TfNSW reference: STH25/00160/002

Your reference: SSD-76440958

SSD-76440958 – MIXED USE DEVELOPMENT WITH INFILL AFFORDABLE HOUSING – PUBLIC AUTHORITY CONSULTATION – 221 TO 291 CROWN STREET, 216 TO 238 KEIRA STREET AND 86 TO 90 BURELLI STREET, WOLLONGONG

Attachment 1

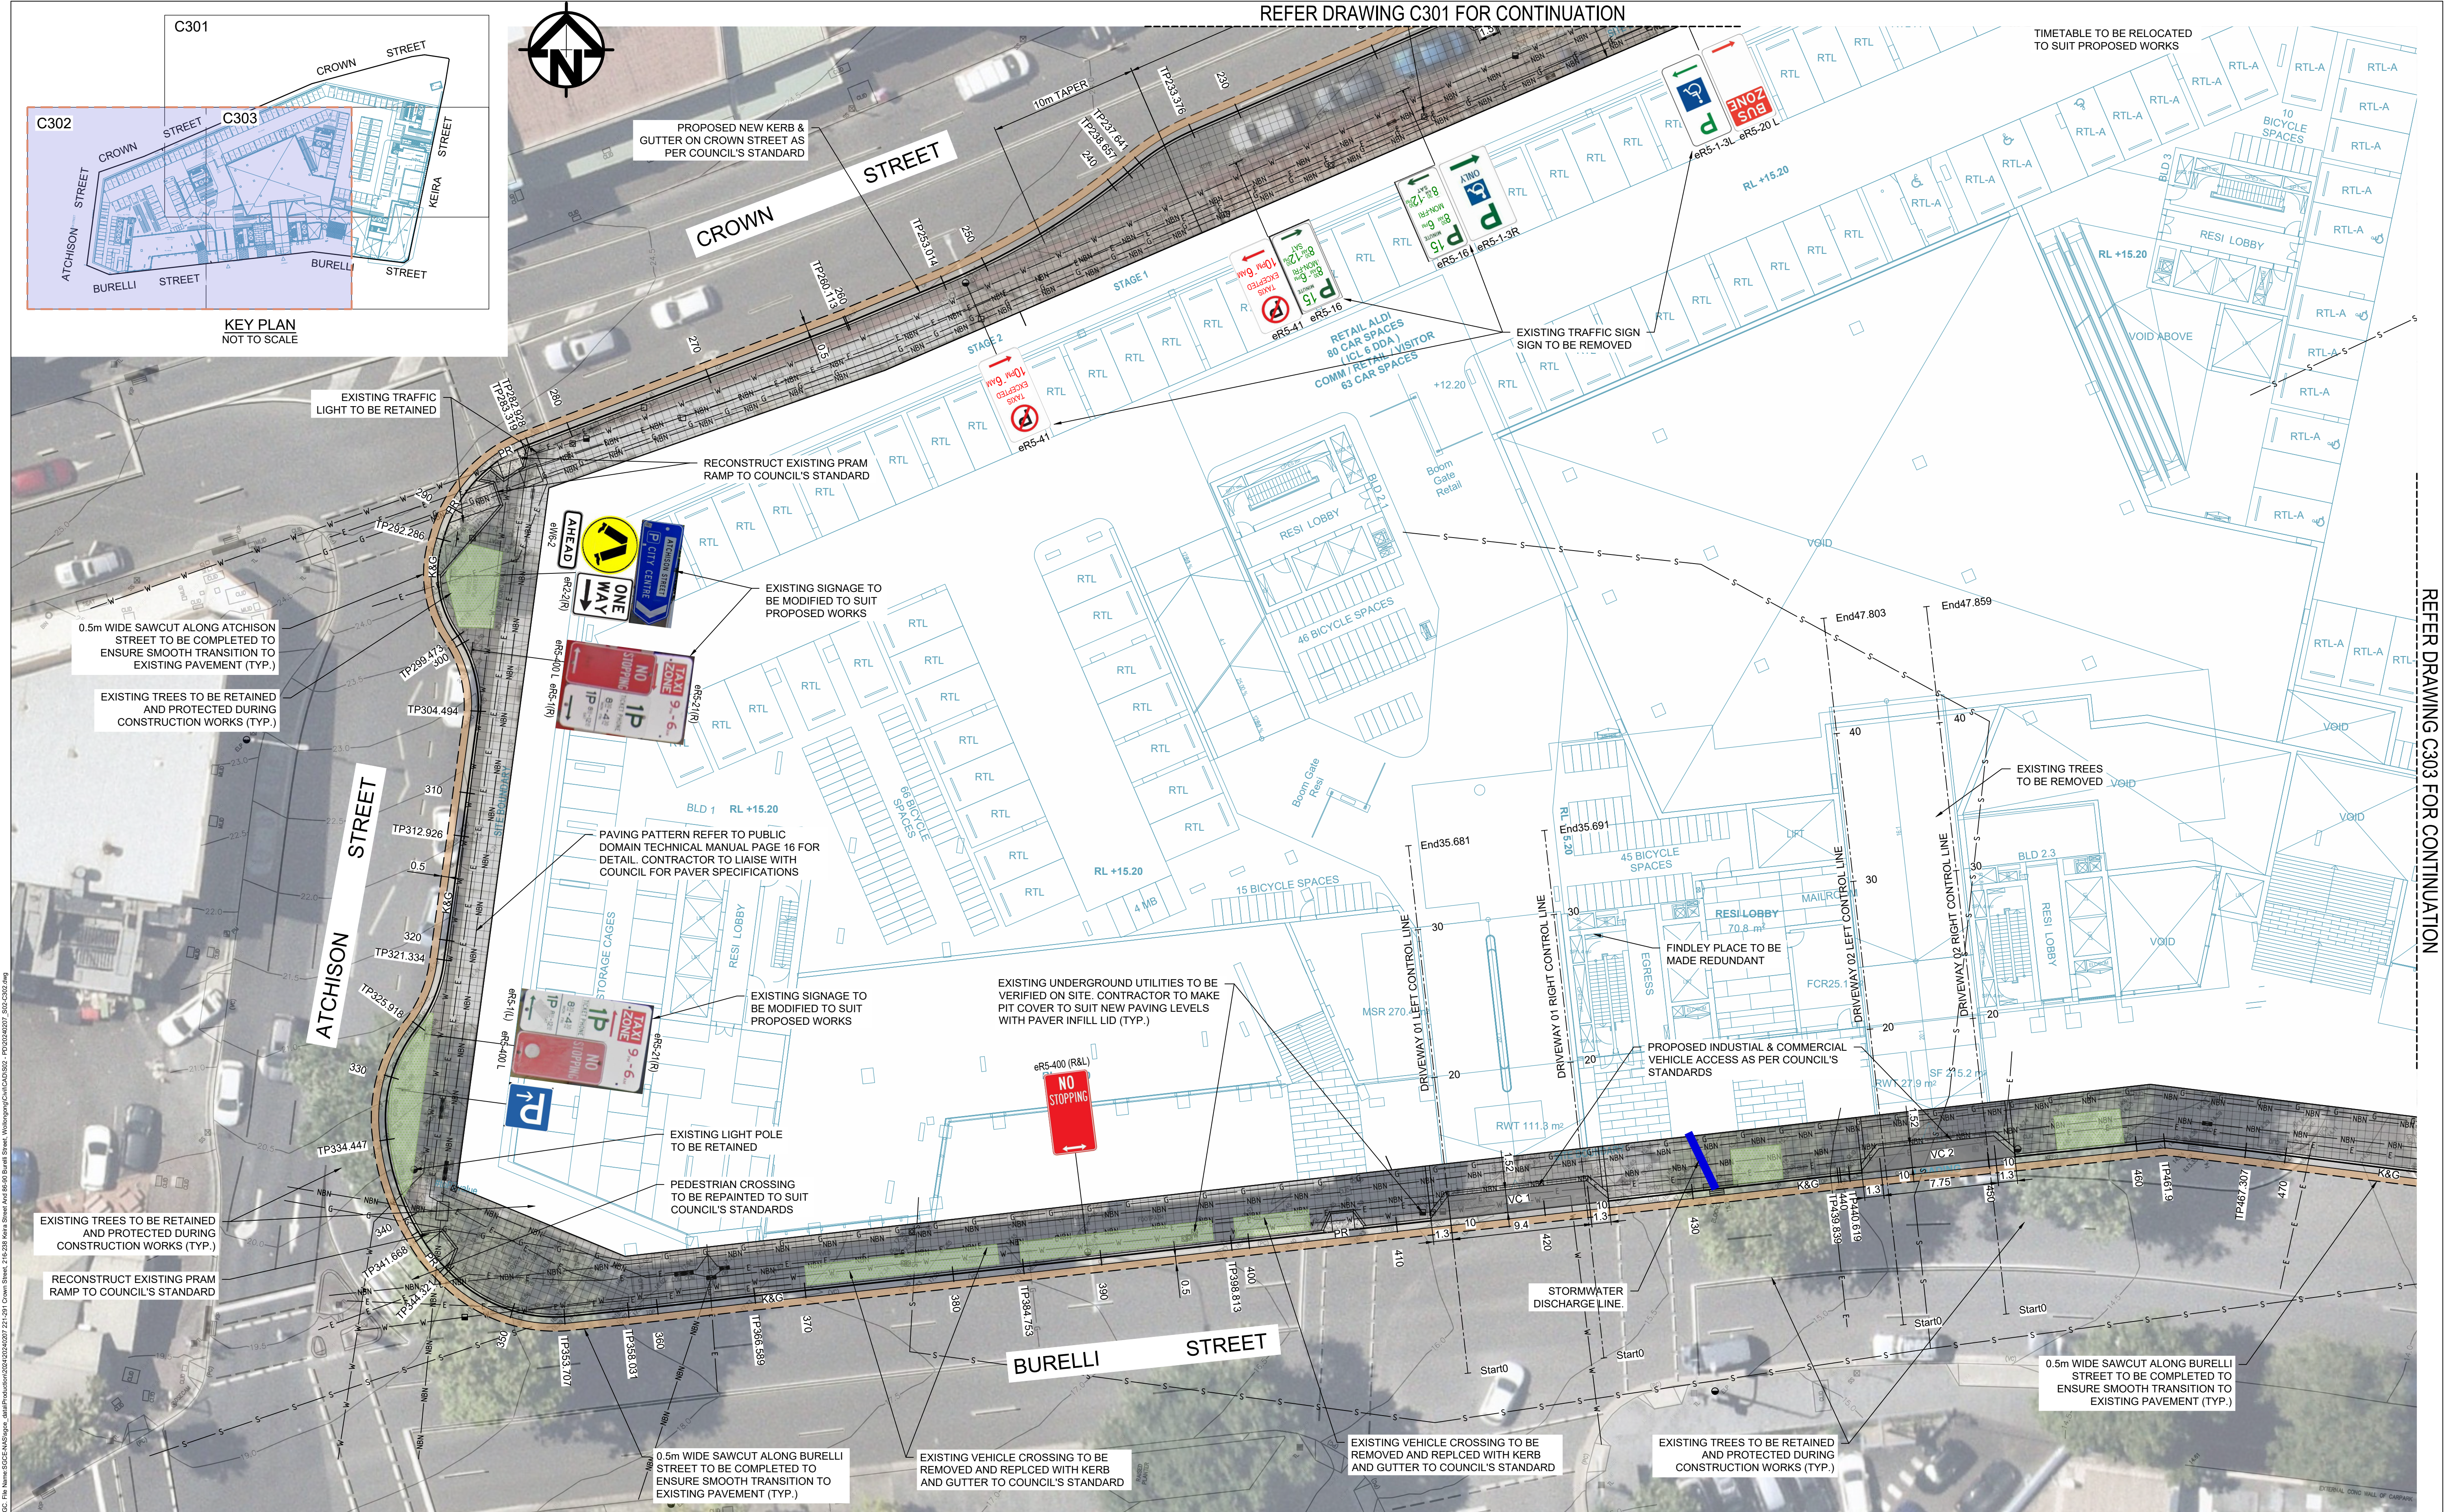
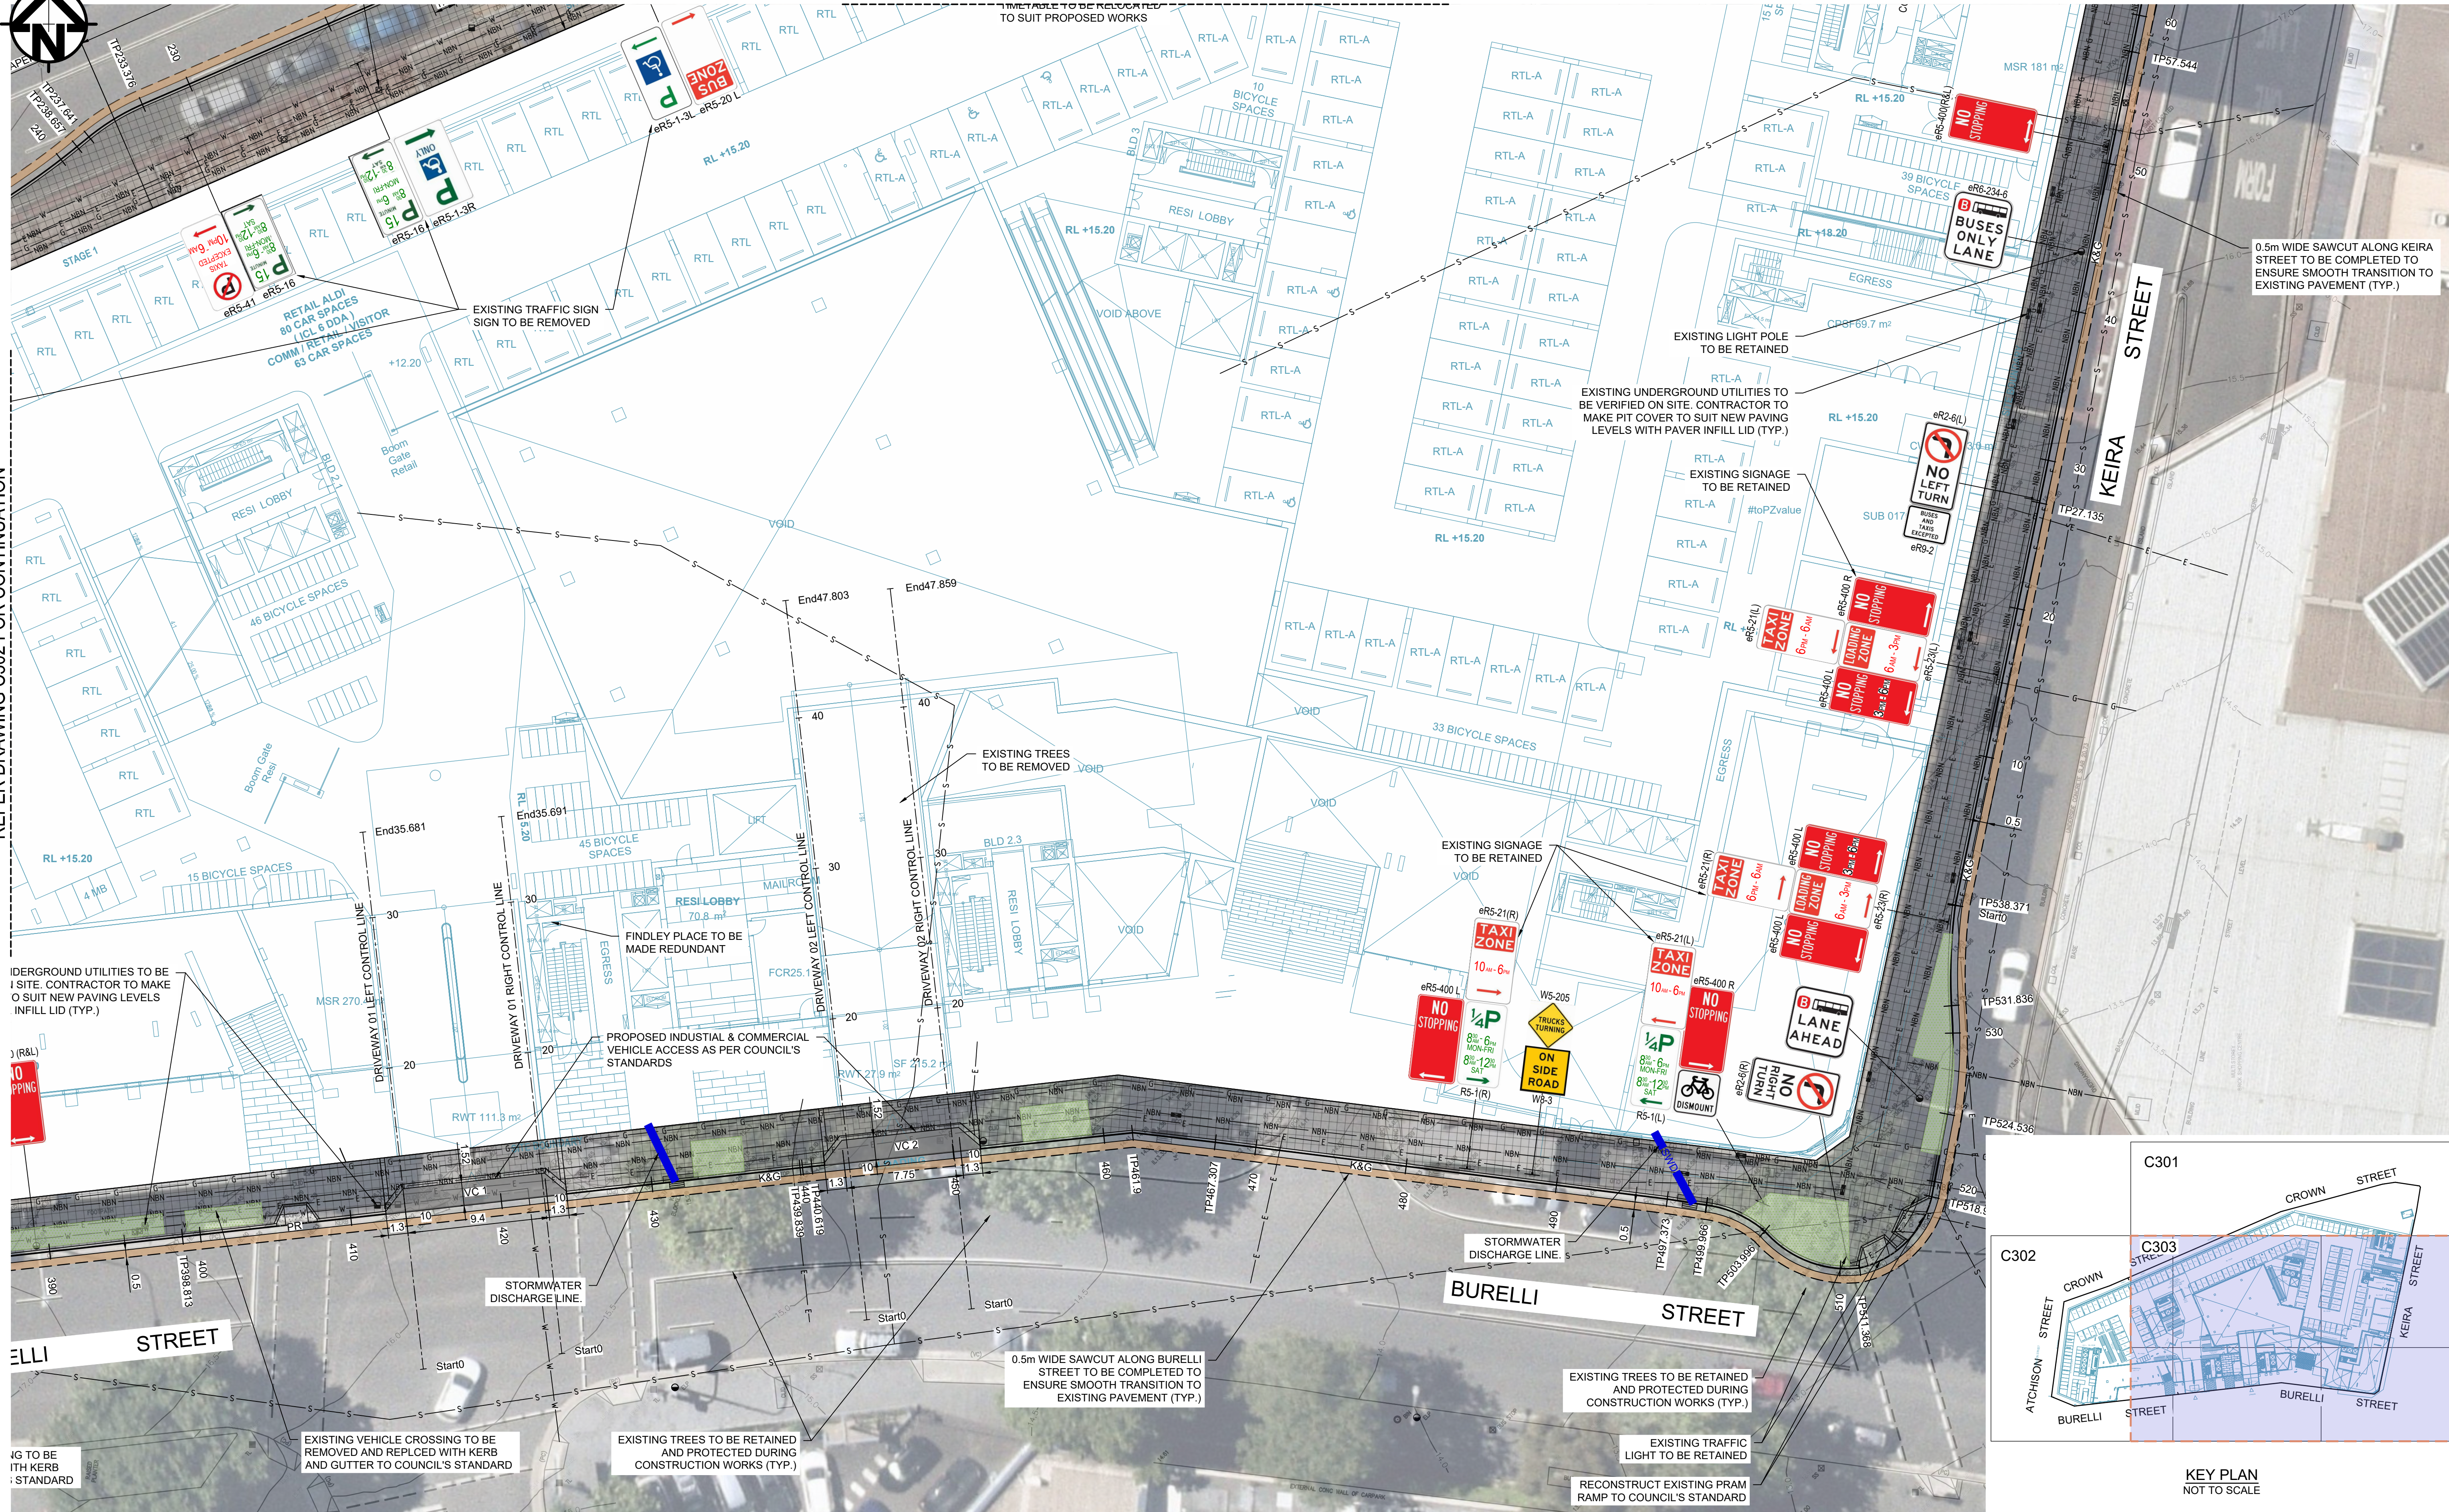
- i) The plan submitted (Public Domain Concept Design, prepared by S&G Consultants Pty Ltd with reference Project No. 20240207, Dwg No. SC02-C301, Revision A Dated 24.04.25) includes a 20m taper. The taper represents the draw out length, and this can be reduced to 6m provided the angle of the kerb (between the widened kerb line and the existing kerb line) is appropriate to allow a bus to draw out. This will need to be supported with a swept path analysis for a 12.5m bus.

- ii) The above referenced Public Domain Concept Design plan includes a 43.5m bus zone. Excluding the draw out length described above, the bus zone needs to be a minimum 49m in length.

- b) Insufficient information has been provided to enable TfNSW to support the kerb widening and the associated reduction in travel lanes on Crown Street, as well as a pedestrian crossing that is proposed within the Crown Street kerb widening (refer to S&G Consultants Pty Ltd Public Domain Concept Plans). To enable TfNSW to undertake an assessment, plans are required that:

TfNSW also notes inconsistencies between the Detailed Landscape Plan prepared by Land+Form (Drawing No. LD-DA101, Revision 1, dated 15.09.2025) and the Public Domain Concept Design prepared by S&G Consultants Pty Ltd. For example, the pedestrian crossing shown in the concept design is not reflected in the landscape plan. Furthermore, both the Environmental Impact Statement and the Traffic Impact Assessment are silent on the proposed outdoor dining along the Crown Street frontage.

- a) The length of the bus zone that is a minimum of 55m to provide sufficient length for three buses to utilise the bus stop at the same time, including any of the three buses to exit upon completion of boarding. This 55m includes a minimum 6m draw out length at the start of the bus zone (the eastern end). Refer to Section 3.7 of the *State Transit Bus Infrastructure Guide*, Issue 2. In achieving the 55m, it should be noted:
